A303 Amesbury to Berwick Down

**8.3(1) - Statement of Common Ground – Historic Buildings
and Monuments Commission for England**

August 2019

STATEMENT OF COMMON GROUND – Historic Buildings and Monuments Commission for England

Drawing Title
STRUCTURES DRAWINGS
EASTERN TUNNEL PORTAL
REGULATION 5(2)(o)
SHEET 11 OF 13

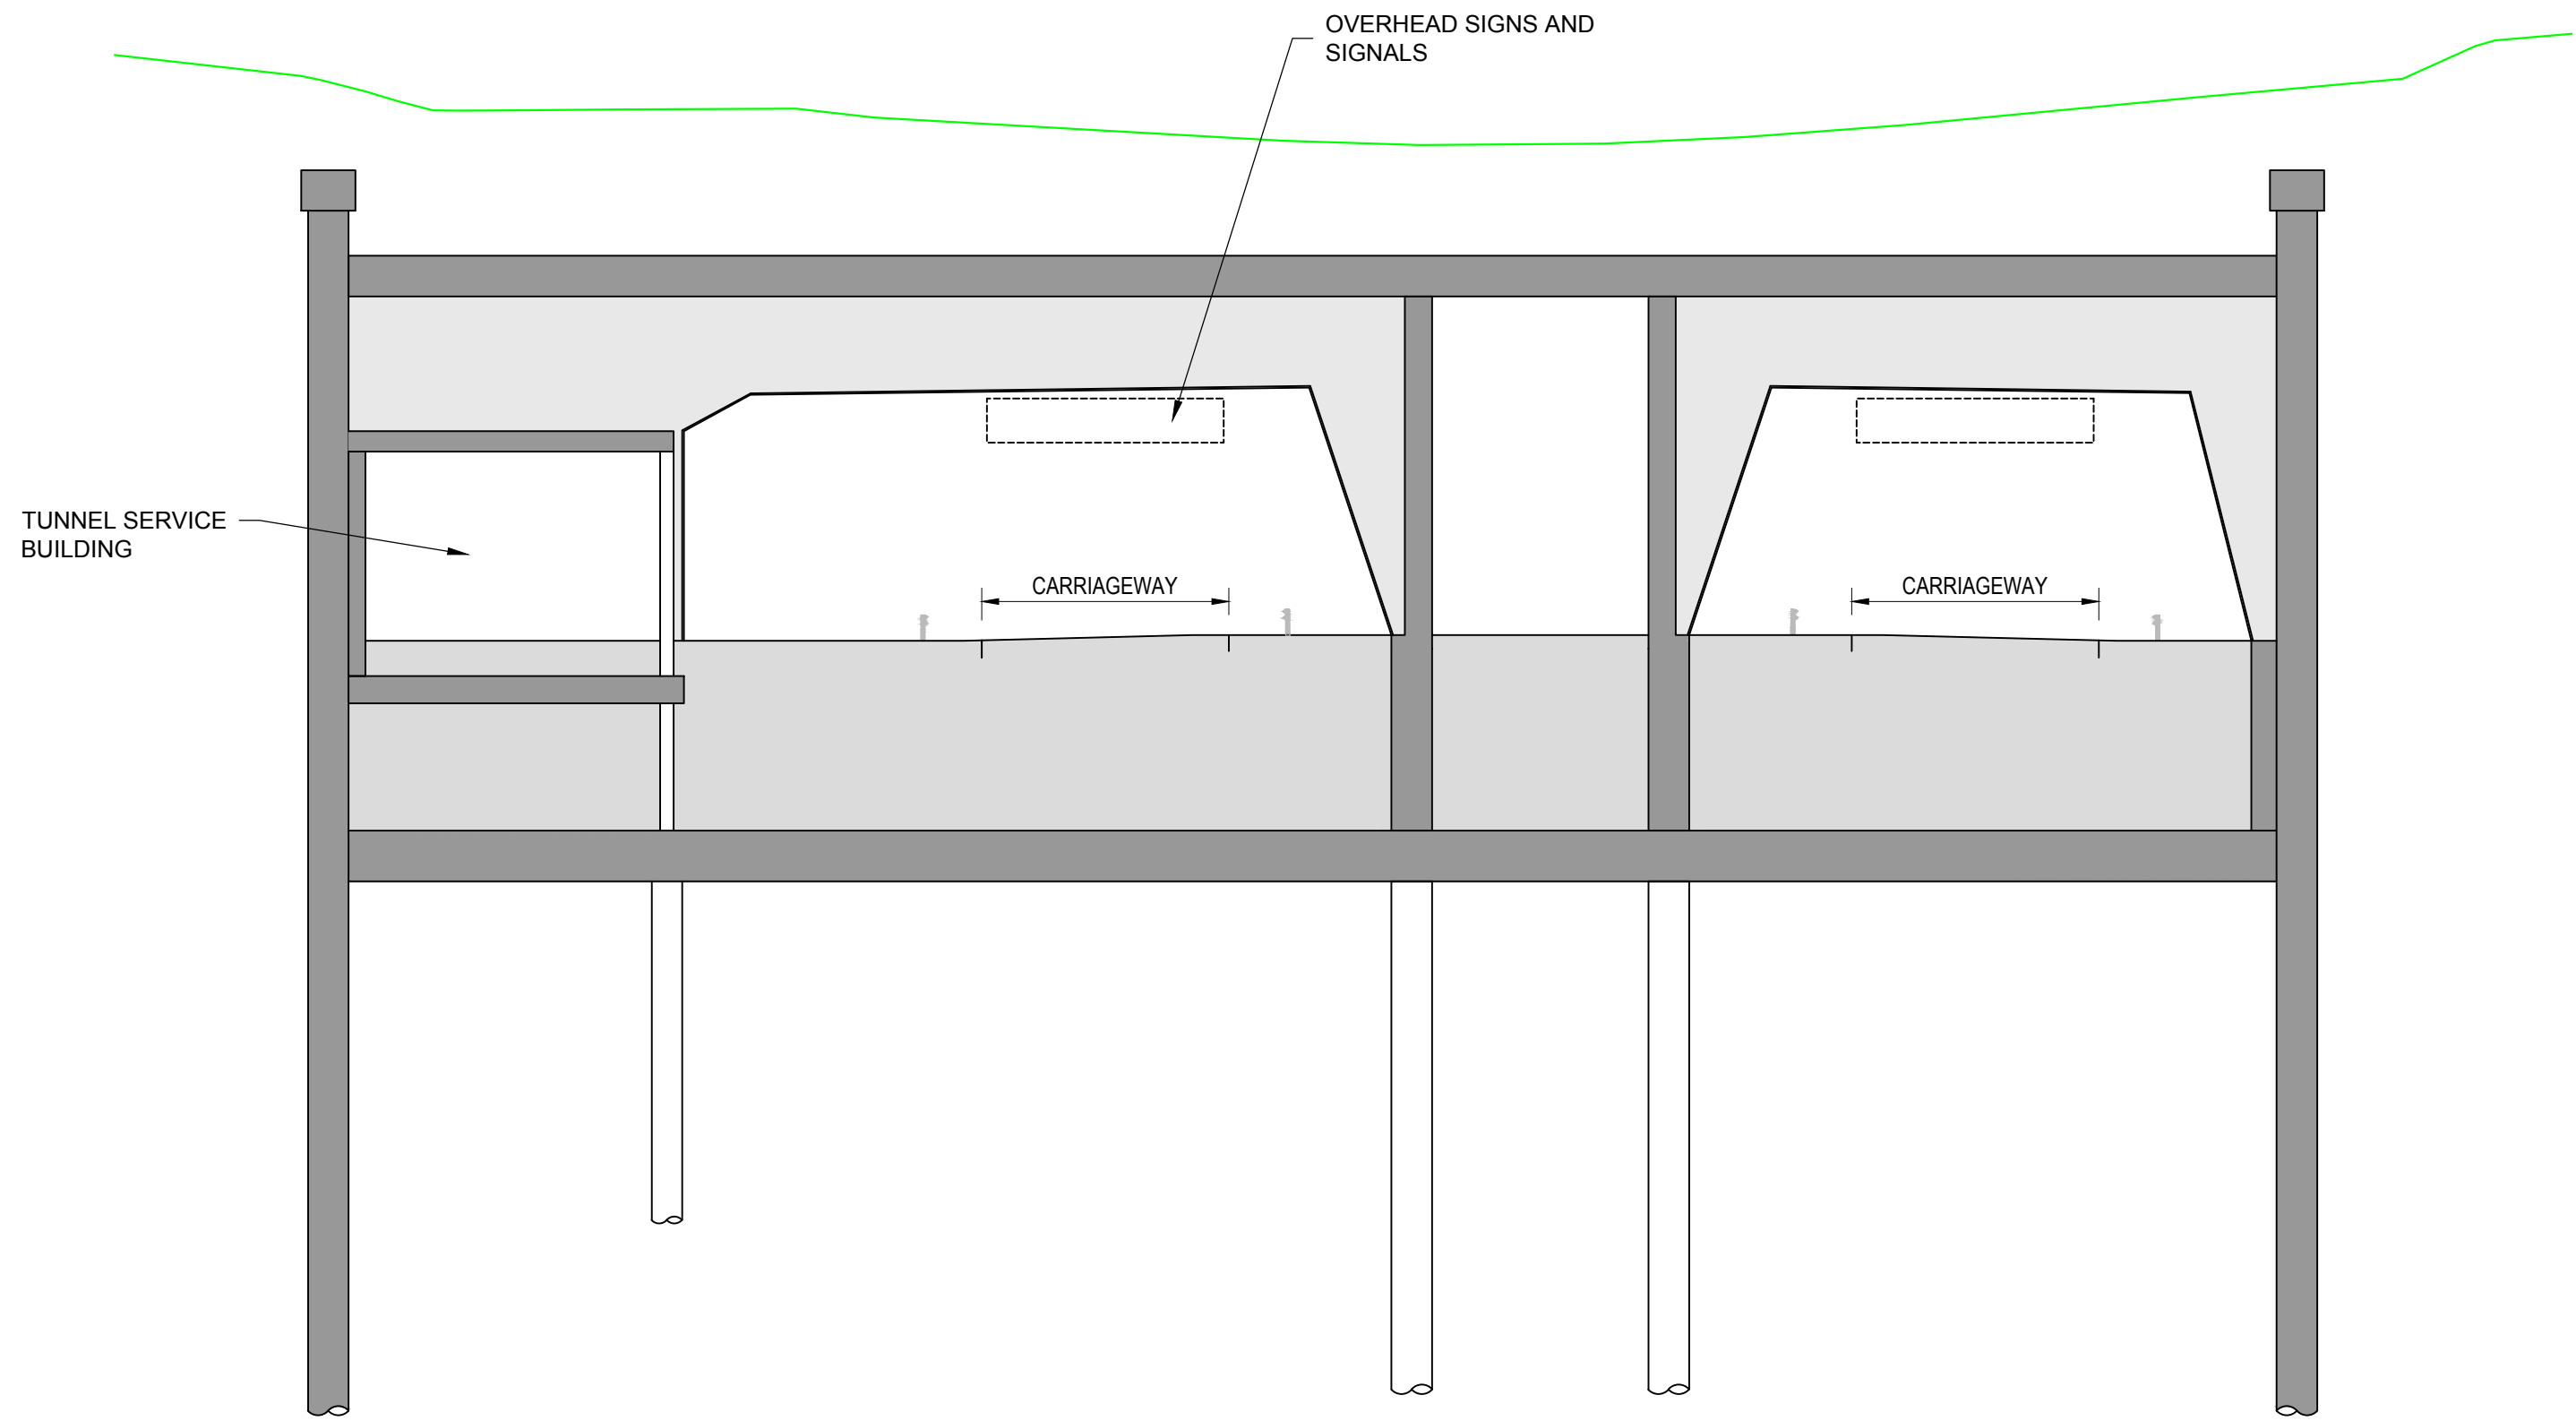
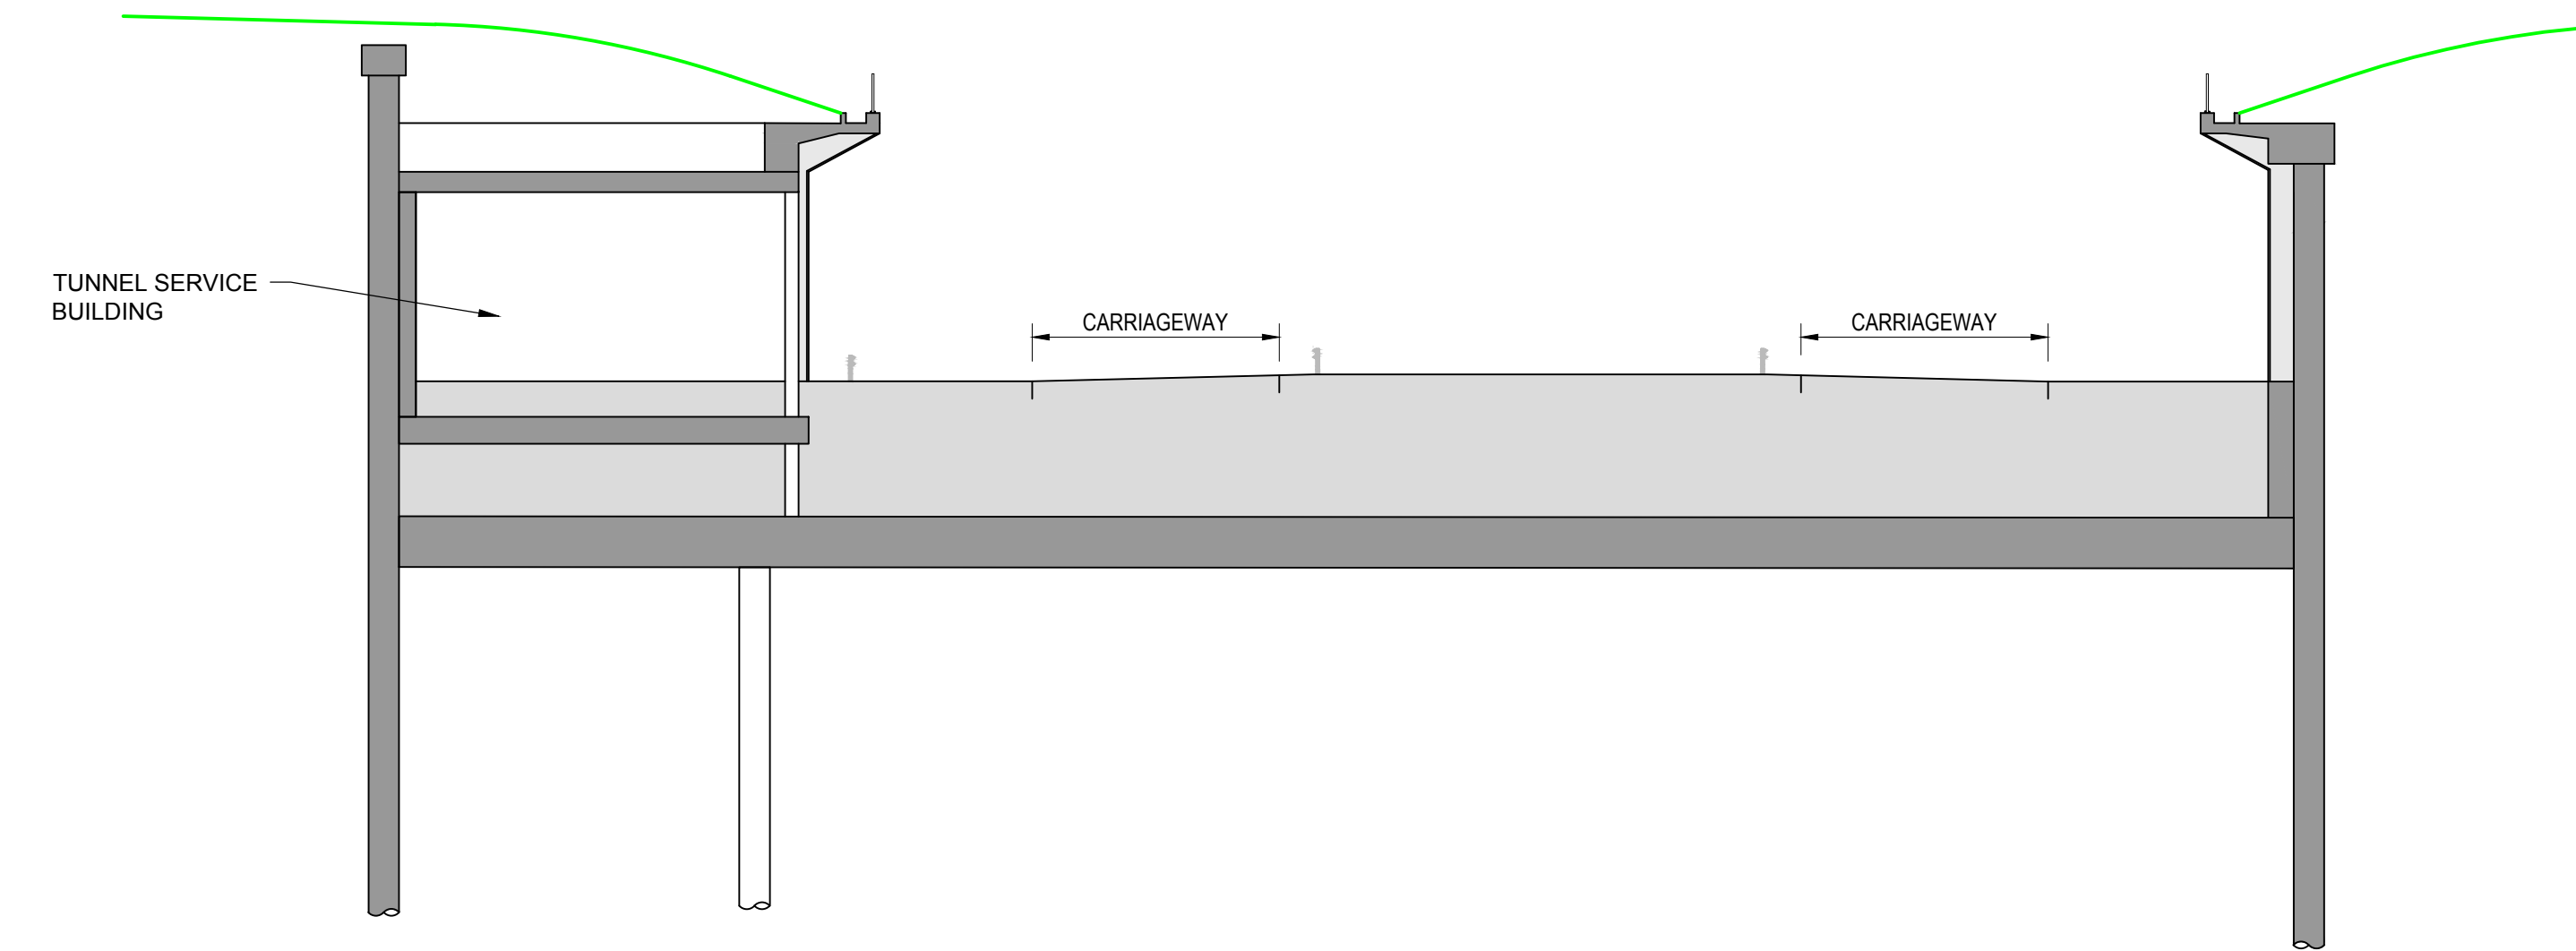
<p>[REP6-053]</p>	<p>ExA question DCO.2.51 – Requirement 4, OEMP</p>	<p>Page 10</p>	<p>Detail is needed in relation to the tunnel canopies, including design detail, confirmation of their positioning, and landscape proposals to understand how they will be integrated into the landscape.</p> <p>A greater degree of precision is needed in relation to the actual positioning of the tunnel portals given the sensitivity of the landscape. Historic England considers the limits of lateral deviation westwards in the first draft DCO of 200m for the western portal to be unjustified at this point.</p> <p>Detail is needed in relation to the management of light levels (both from infrastructure and vehicle headlights), because of effects of light on the night time historic environment, in particular, in relation to the tunnels and retained cuttings within the SAAS WHS.</p> <p>In our Written Representations [REP2-100] (paragraph 7.6.24) HBMCE indicated that whilst it is possible that some aspects of lighting for the Scheme might be comfortably addressed at Detailed Design Stage, sufficient indication of the parameters for decision making must be subject to Examination. We advised that this might be addressed through production of a lighting strategy for the Scheme. In</p>	<p>stage immediately before implementation.</p> <p>The OEMP [REP6-011] includes a design vision together with a set of design principles for key elements of the Scheme. Highways England will consult key stakeholders, including HBMCE, on the external appearance of the following elements of the Scheme within the World Heritage Site:</p> <ul style="list-style-type: none"> a) The tunnel service buildings (Work No.1D(ii)); b) Portals structures (Work Nos. 1E(ii) and 1G(iii)), retaining walls (part of Work Nos. 1D(ii) and 1H(ii)) and Green Bridge Four (Work No.1d(i)); and c) Public rights of way, including pedestrian, cycling and non-motorised user provision and wayfinding including surfacing, materials, fencing and gating. <p>Outside of the World Heritage Site Highways England will consult key stakeholders, including HBMCE, on the external appearance of the following:</p> <ul style="list-style-type: none"> a) Signing and lighting at the new Longbarrow junction (Work No.1C(ii)); and b) Signing and lighting at the Countess junction (Work No.1H(iv)).

<p>Current position</p>			<p>relation to the tunnel portals specifically (7.6.50) we advised that clarification regarding how light levels will be managed at these points in the landscape to avoid any harm to Attribute 4 of the OUV of the WHS. Subsequently HBMCE have continued through heritage design meetings in relation to the OEMP to discuss the provision for lighting design at the tunnel portals and elsewhere where there is potential for the WHS to be affected.</p> <p>As noted above, the OEMP remains the focus of discussion on the detail of the Scheme. We would expect the detailing of key engineering elements to be covered as part of this discussion.</p>	<p>Longbarrow Junction</p> <p>The layout of the proposed Longbarrow junction is shown on sheet 5 of the Works Plans [APP-008], described in Schedule 1 and shown indicatively on Sheet 5 of the General Arrangement Drawings [APP-012]. The junction has been located as close as possible to the point of intersection of the A303 and A360 alignments while at the same time minimising impact on the WHS and other environmental receptors.</p> <p>Tunnel Approaches and Portals</p> <p>Visualisations of the tunnel approaches and portals can be found in section 6.4 of the Design and Access Statement [APP-295]. Further detail is shown illustratively on sheets 7, 8, 10 and 11 of the Structures Drawings [APP-017]. Additional visualisations were submitted at Deadline 6, which are currently being reviewed by HBMCE. Further visualisations, in response to ongoing dialogue, are being submitted at Deadline 7.</p> <p>Levels in relation to existing Topography</p> <p>Proposed road levels in relation to existing ground levels are shown in the Engineering Drawings (Plans and Profile) [APP-010]. These drawings</p>

<p>within and beyond the WHS, considering such matters as; landscaping, structures, surfacing, lighting and public rights of way.</p> <p>A description of the earthwork landscape proposals is included in paragraph 2.3.55 of Chapter 2 of the ES [APP-040] For further detail refer to ES chapter 7 2 Landscape and Visual Effects [APP-045]. The final landscaping for the Scheme is controlled by requirement 8, which requires a landscaping scheme to be approved by the Secretary of State for each part of the Scheme before it is commenced.</p> <p>Lighting</p> <p>The majority of the Scheme would not be lit. There will be no external road lighting within the WHS outside the tunnel or Green Bridge 4 and this lighting will be designed to avoid light spill. There will be no lighting to retaining cutting walls or the external walls of tunnel control buildings during the routine operation of the Scheme. The existing lighting provision at Countess roundabout will be replaced with a modern system that will reduce light spill. The lighting under Green Bridge No. 4 will only operate during the day time and will be dimmer controlled at dusk and dawn to avoid</p>

<p>sudden bursts of light emitting into the landscape at these specific times of the day. There will be no lighting on any PRow within the Scheme. This lighting is provided for in the OEMP [REP6-011], and paragraph 4 of Schedule 2 of the draft development consent order [REP6-005] requires the Scheme to be carried out in accordance with the OEMP.</p> <p>Green Bridge No 4</p> <p>Highways England has committed, via the OEMP [REP6-011] to the width of Green Bridge No. 4 being 145 – 149.9 metres. It also contains the design vision, additional design commitments, design principles to help guide the development of the detailed design together with a robust stakeholder consultation mechanism to involve heritage stakeholders, including HBMCE, in the development of aspects of the detailed design. Compliance with the OEMP is secured via requirement paragraph 4 of Schedule 2 of the draft development consent order [REP6-005].</p> <p>Tunnel Canopies</p> <p>Highways England has prepared an update to the OEMP [REP6-011] which contains additional design commitments (including in relation to</p>
